**WEST SUSSEX COUNTY COUNCIL
PRE-APPLICATION CONSULTATION**

DATE: 5th September 2017

TO: Odyssey FAO: Thomas Maloney
FROM: Stephen Gee
SUBJECT: PRE-076-17
Development of 550 Dwellings.
Land South West of, Loveys Road, Yapton

Scale 1:500 @A1	Date DEC 17	Designed SD
Drawn SD	Checked MS	Approved R.JH
Job No 14-111	Drawing No 14-111/202	Rev

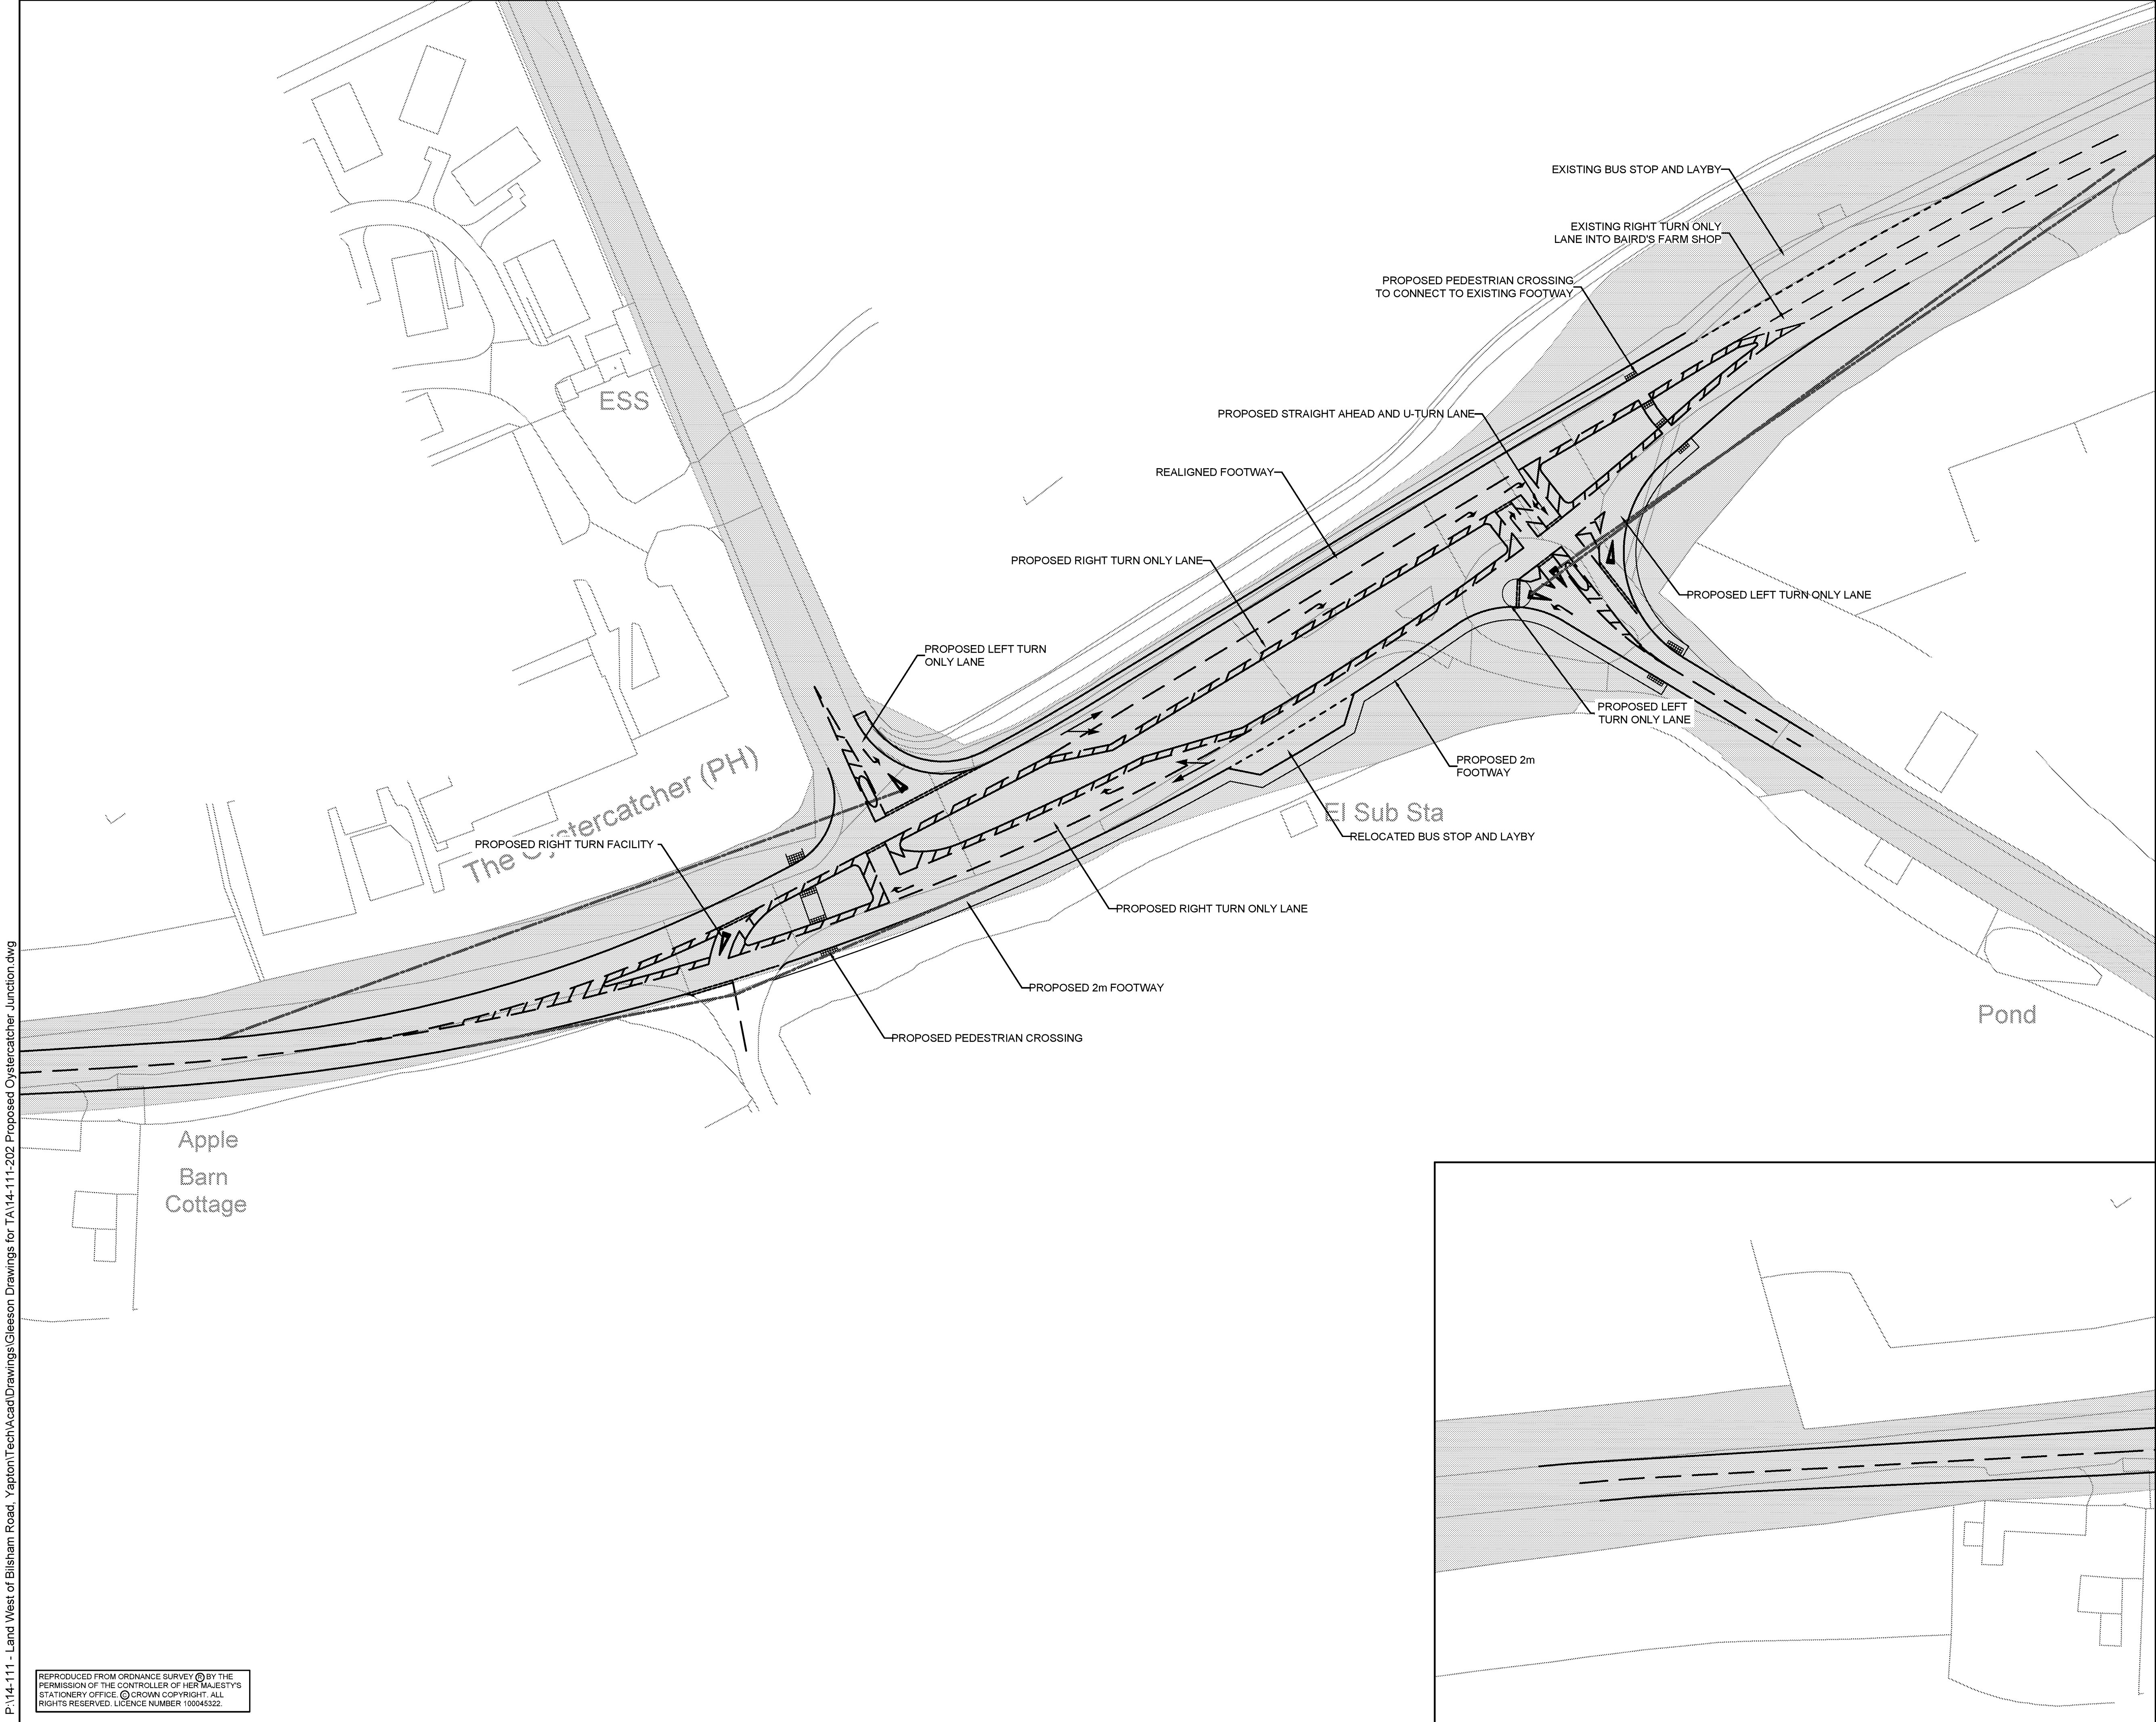
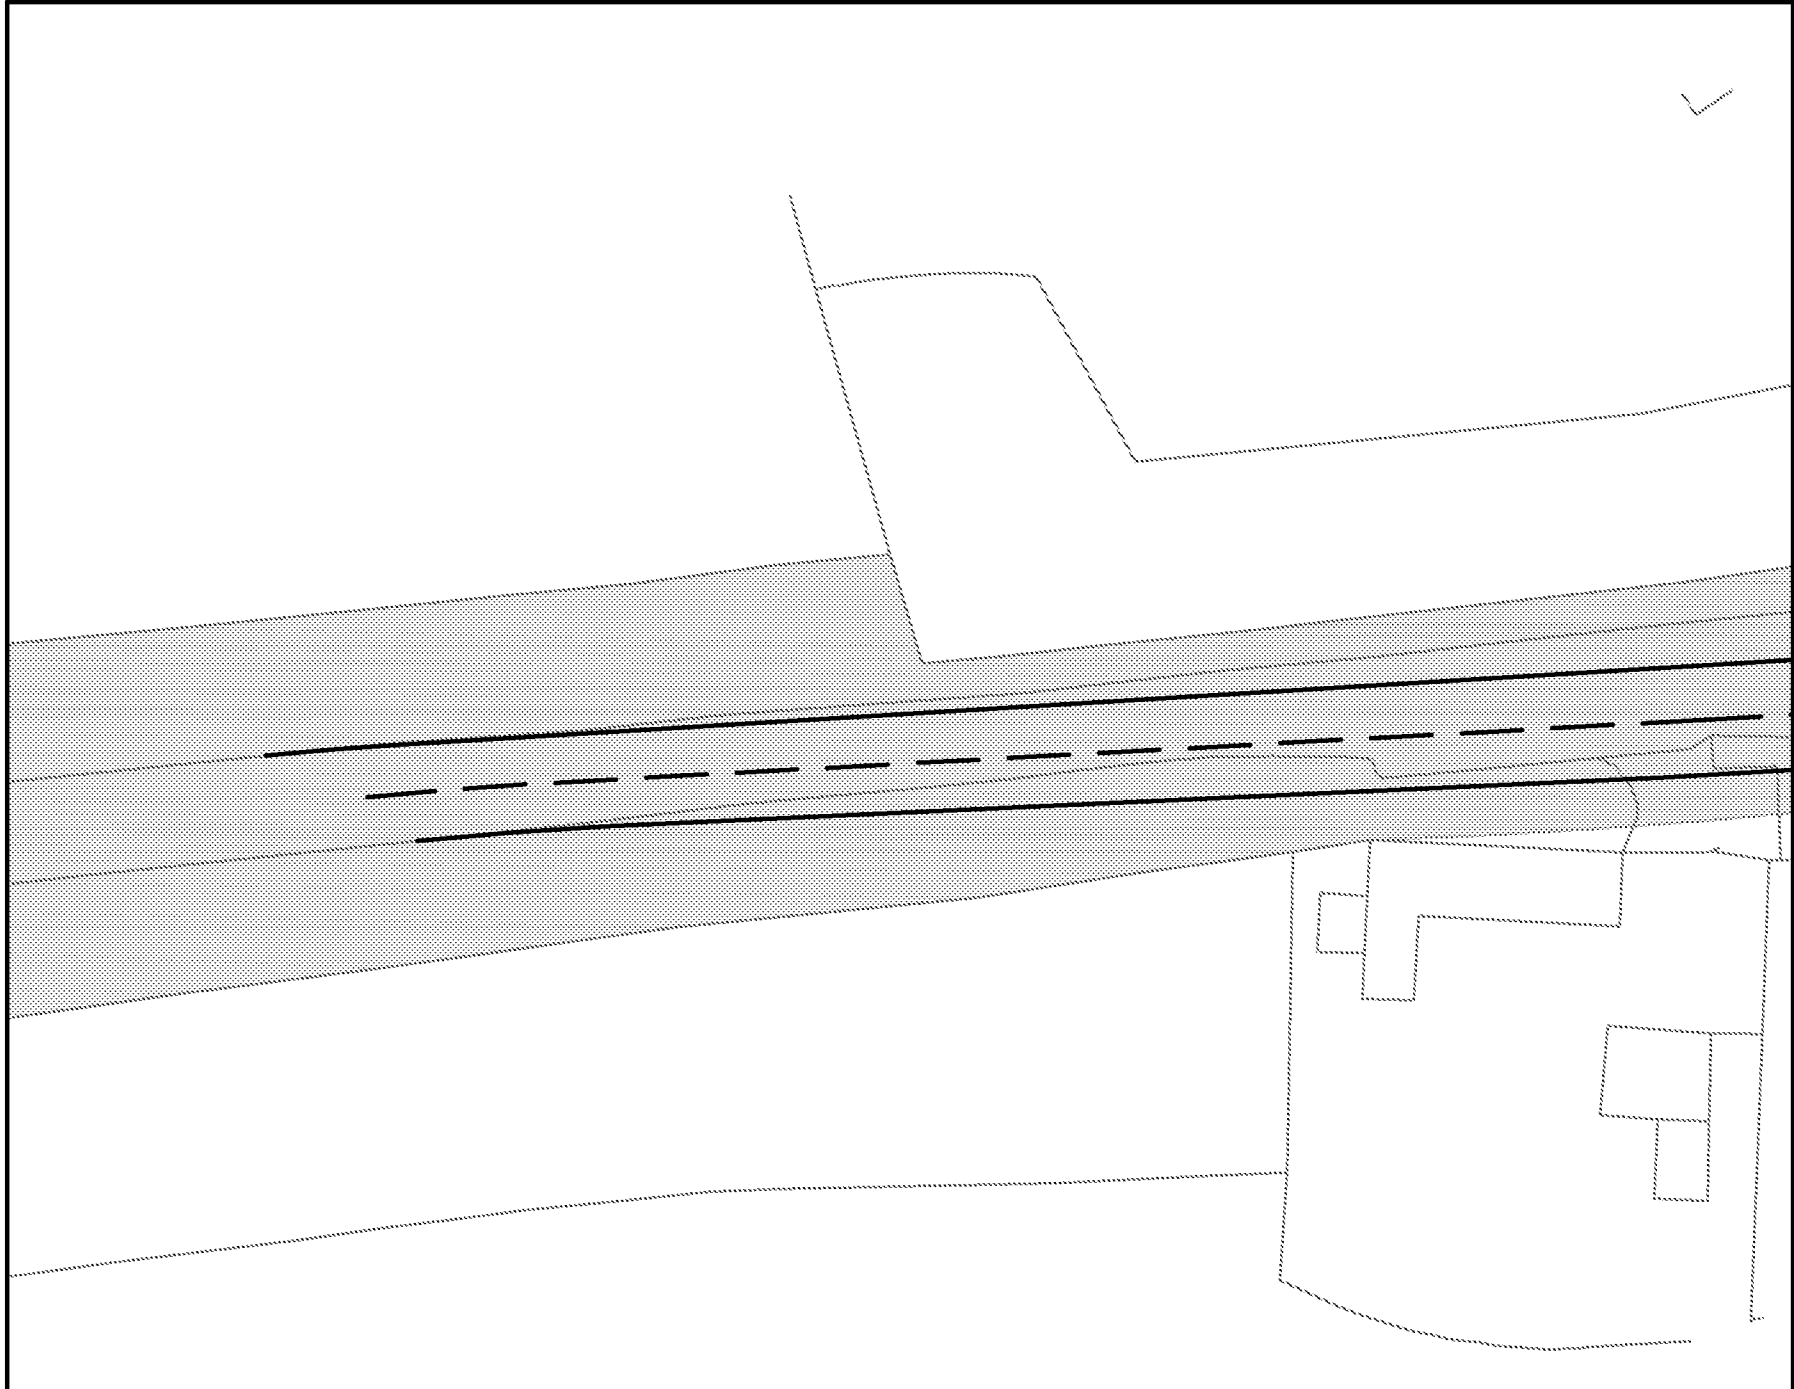
A number of junctions were highlighted that are likely to require mitigation as a result of the development including Main Road/North End Road, Comet Corner, Oystercatcher and Bilsham Road/Burndell Road. It would be helpful within any future submission that it is clear on how any costed mitigation would be split between the two land owners/planning applications.

-  HIGHWAY BOUNDARY (EXTRAPOLATED FROM PLAN PROVIDED BY WEST SUSSEX COUNTY COUNCIL)
-  2.4m x 59m VISIBILITY SPLAY (UPTO 37mph MFS IN ACCORDANCE WITH OBSERVED 85th PERCENTILE SPEEDS OF 35mph NORTHBOUND & 36mph SOUTHBOUND)

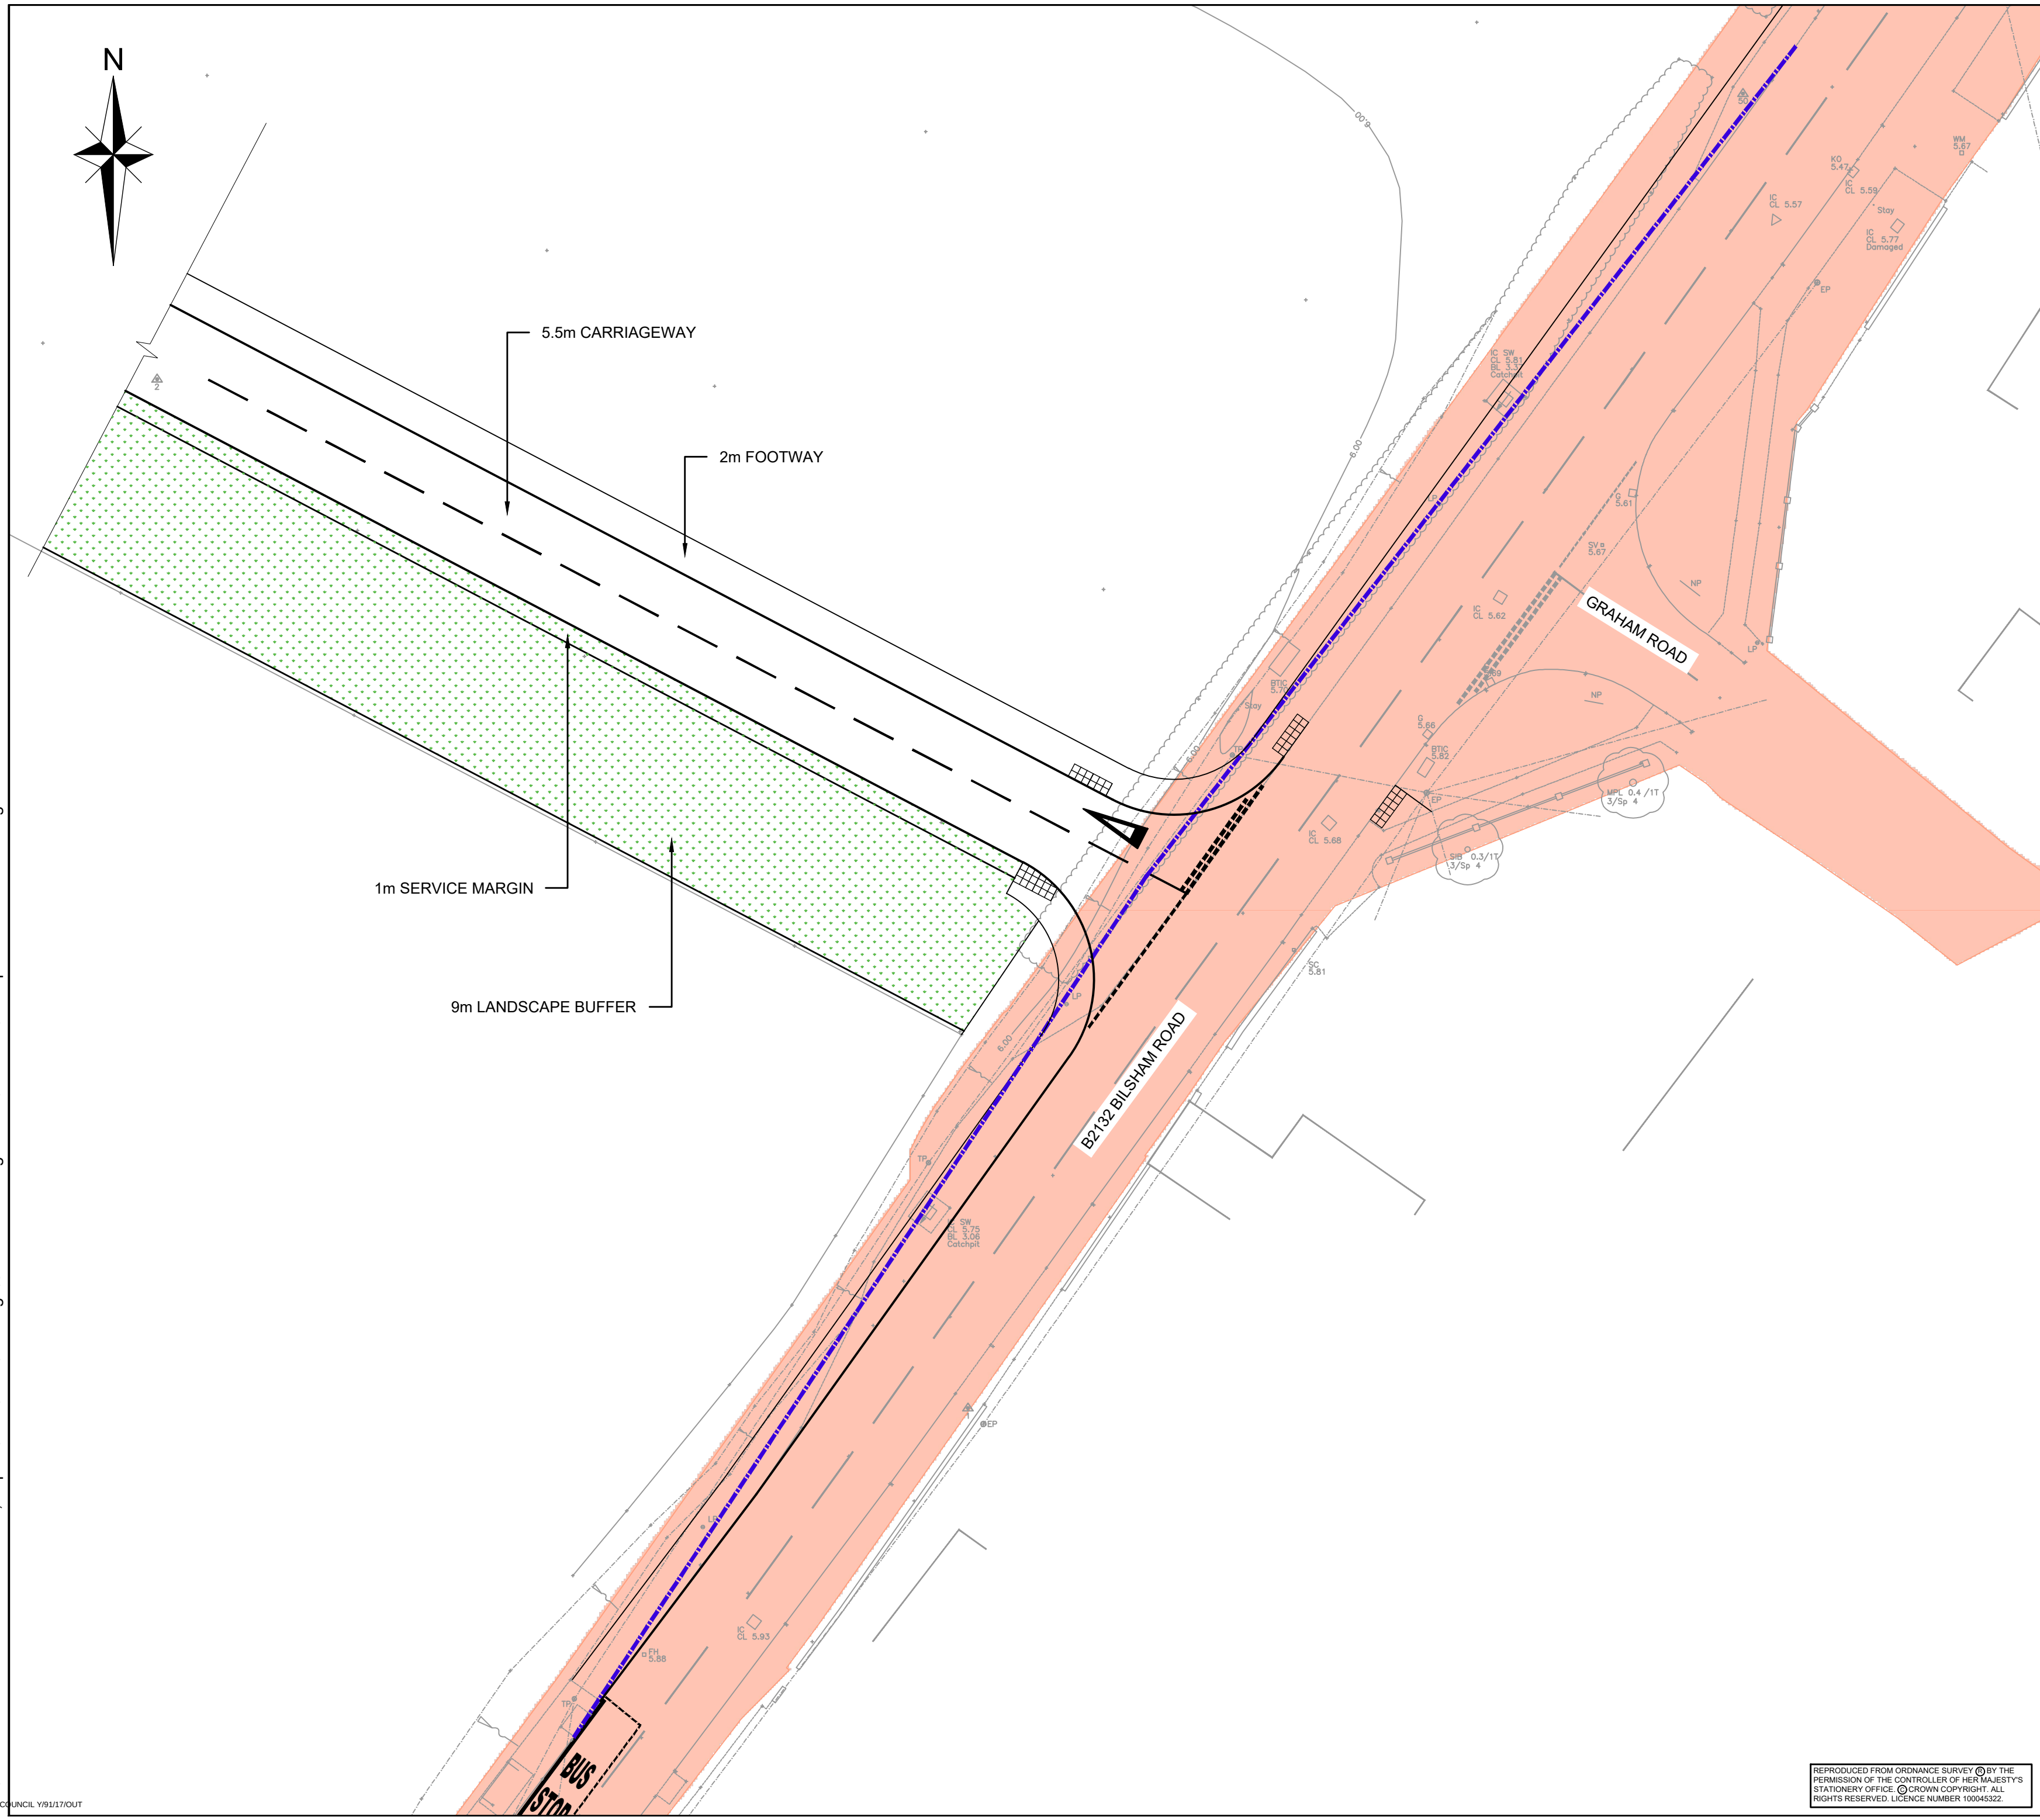
The site will have two points of vehicular access, the first from the B2233 Main Road at Drove Lane and the second from the B2132 Bilsham Road. Both priority junctions can provide visibility splays of 2.4m x 59m based upon observed 85th percentile vehicle speeds which will be submitted with the application. It is proposed that in its end state the two sites will be linked with a single spine road between the Bilsham Road and Main Road accesses.
